DECISION DELEGATED TO HEAD OF PLANNING

Application No:	H02-0717-26	Applicant:	Mr M S Malak
Proposal:	Window Alterations		
Location:	9 South Street Crowland		
Terminal Date:	6th October 2026

Ultimate rose

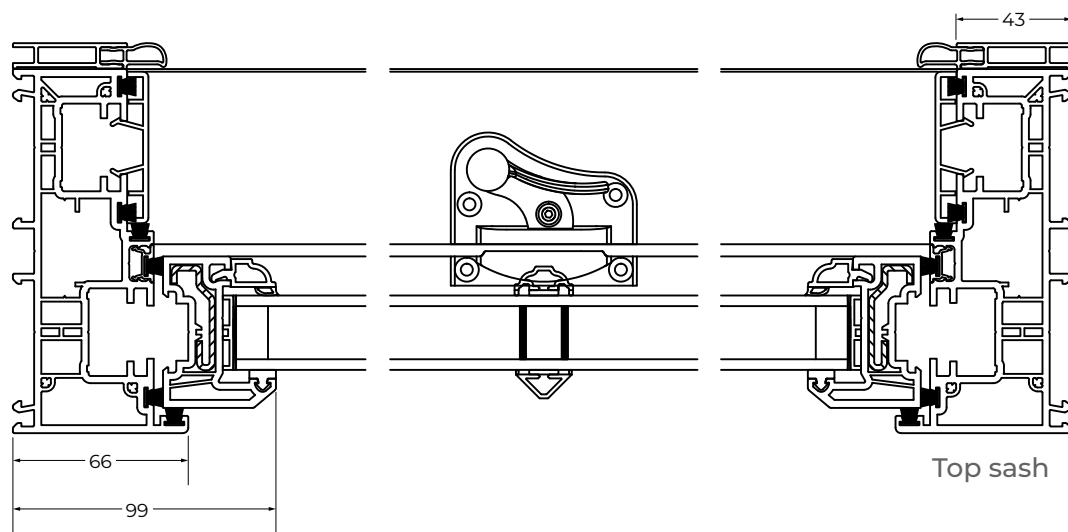
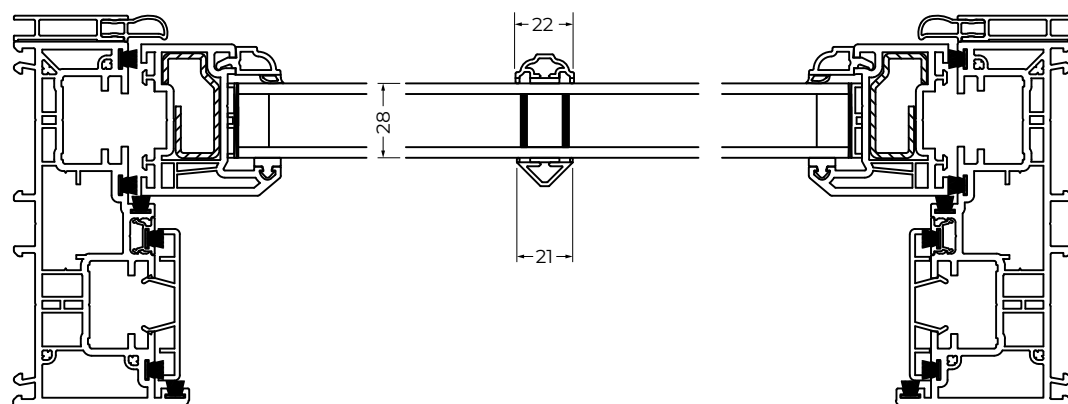
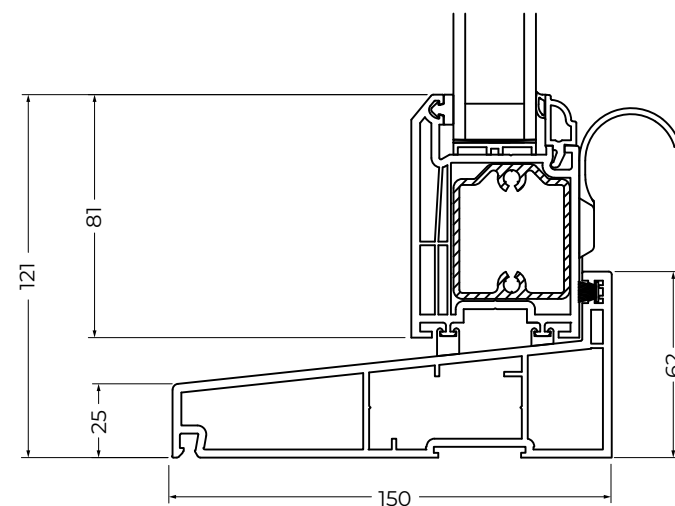
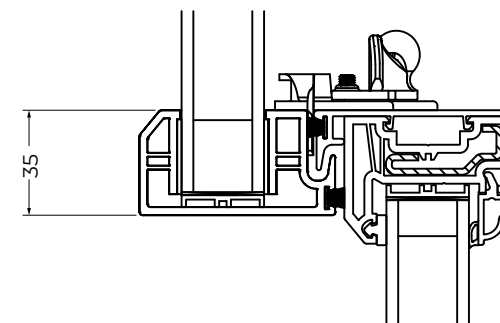
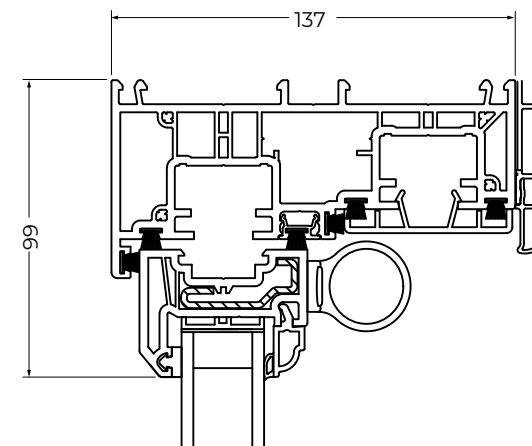
What details we can confirm of the proposed windows from the sectional drawings are not satisfactory either. Astragal bars to replace genuine full bars and full depth double glazing instead of conservation style double glazing which is widely available on the market.

The conservation officer also considers that the sectional drawings suggest that the replacement windows would not be suitable. For example, it appears that astragal bars are proposed to replace genuine full bars, and full depth double glazing is proposed instead of conservation style double glazing which is widely available on the market.
